**Canal &  
River Trust**

Tuesday 3 February 2026

**Proposal: Outline application, including the consideration of access and layout, for two commercial units (use class B2 and/or B8) and associated works**

**Location: Land off Forge Lane, Thornhill Lees, Dewsbury**

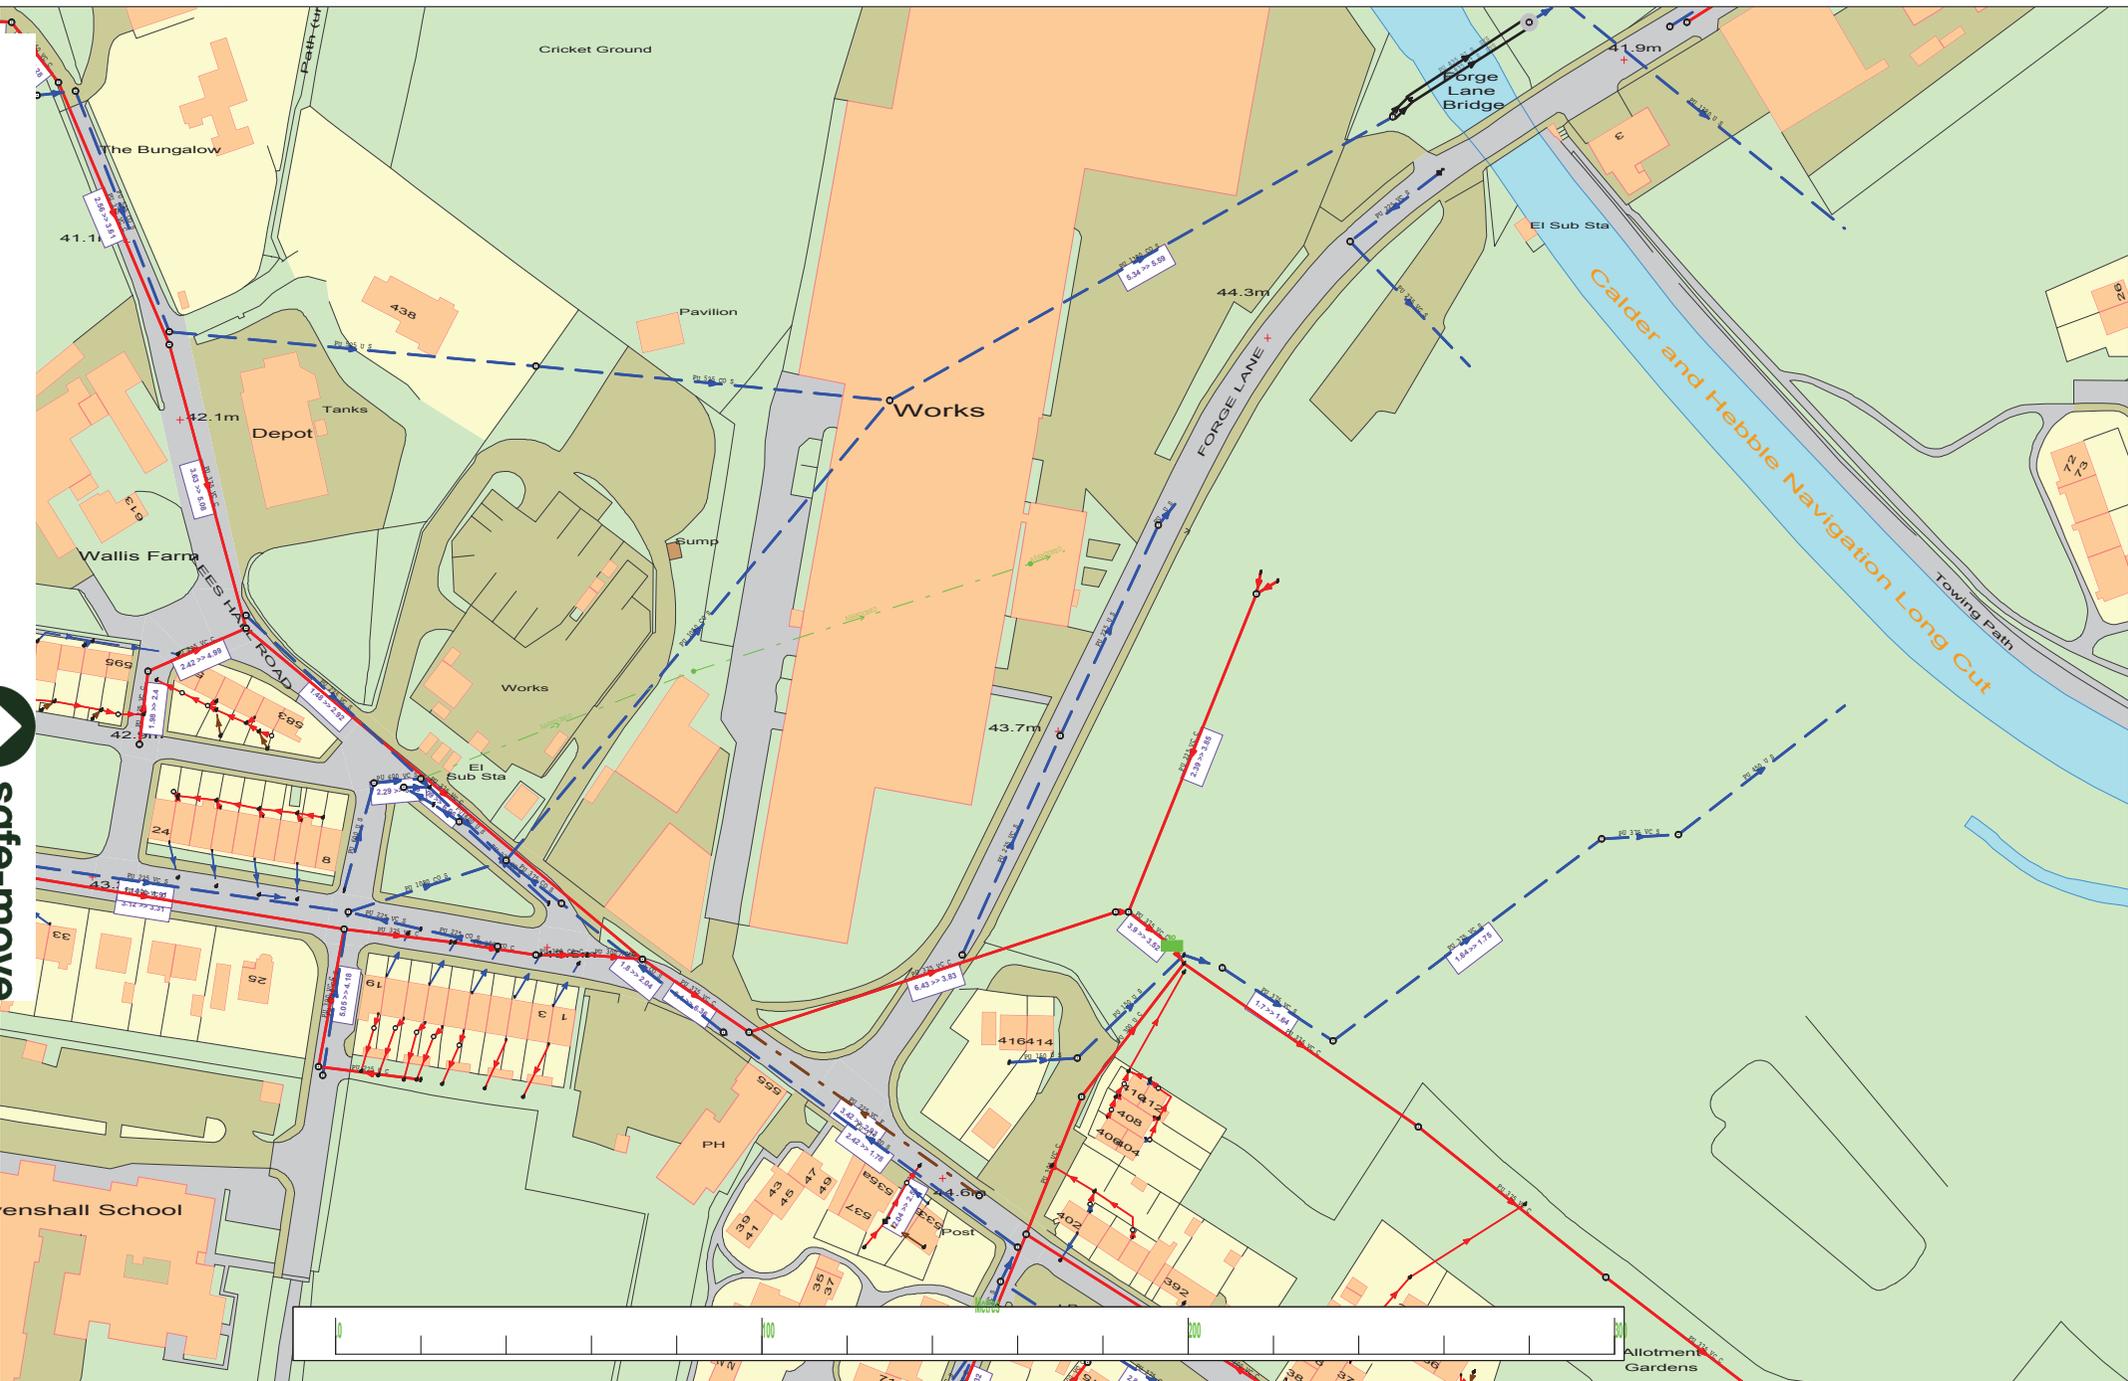
The proposed layout, on which full consent is being sought, proposes to site the new warehouse buildings atop of a cutting which supports the site above the Calder & Hebble Navigation. The site layout levels indicate that the re-grading of the cutting slope is proposed, notably around building 2, which could significantly alter the amount of loading on the slope.

project  
**Forge Lane, Dewsbury**

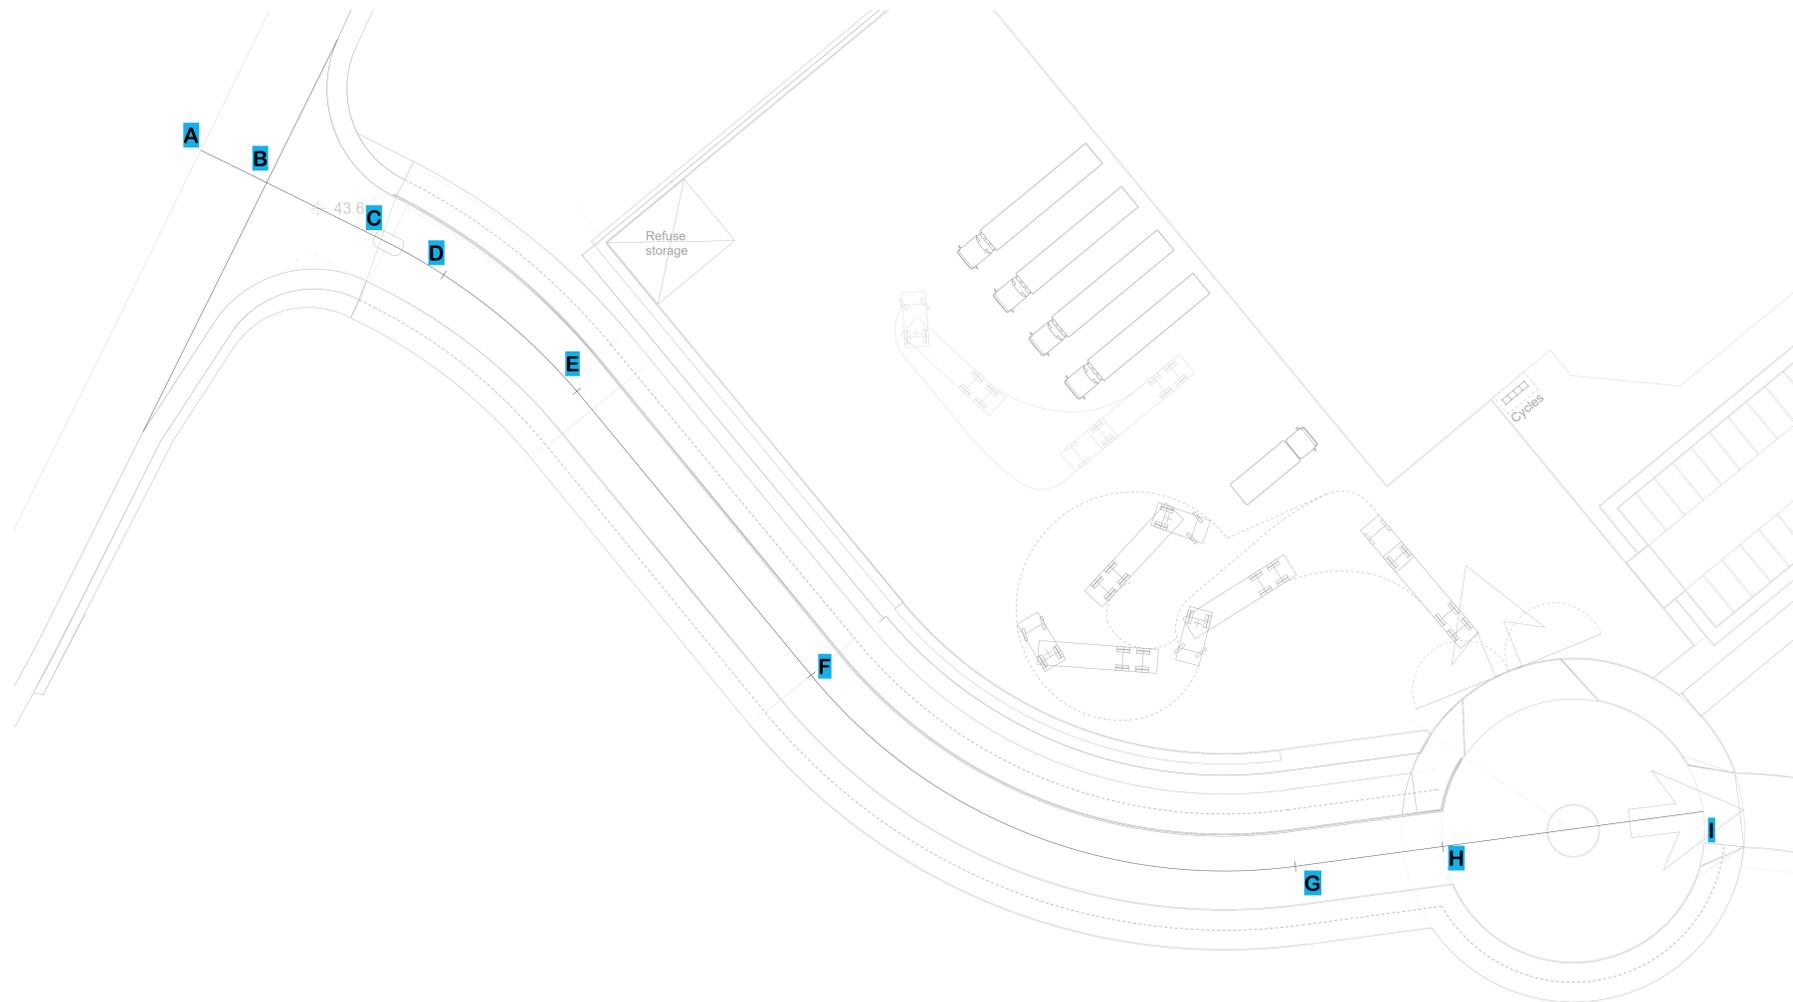
In our previous consultation response on the proposals, dated 9<sup>th</sup> July 2025, we requested that additional cross sections should be provided to demonstrate that the proposals will not impose adverse loading onto the slope.

This is vital to ensure that the risk of land instability and the risk of landslips onto the canal, are properly addressed.

The cross section provided show the relationship of the development to the cutting slope, and show a reasonable separation distance between the development and the top of the slope.

Having reviewed the cross sections provided, the Trust is satisfied that the risk of the development on land instability should not be significant. As a result, **the information provided is considered acceptable, and appropriately addresses our original comments.**
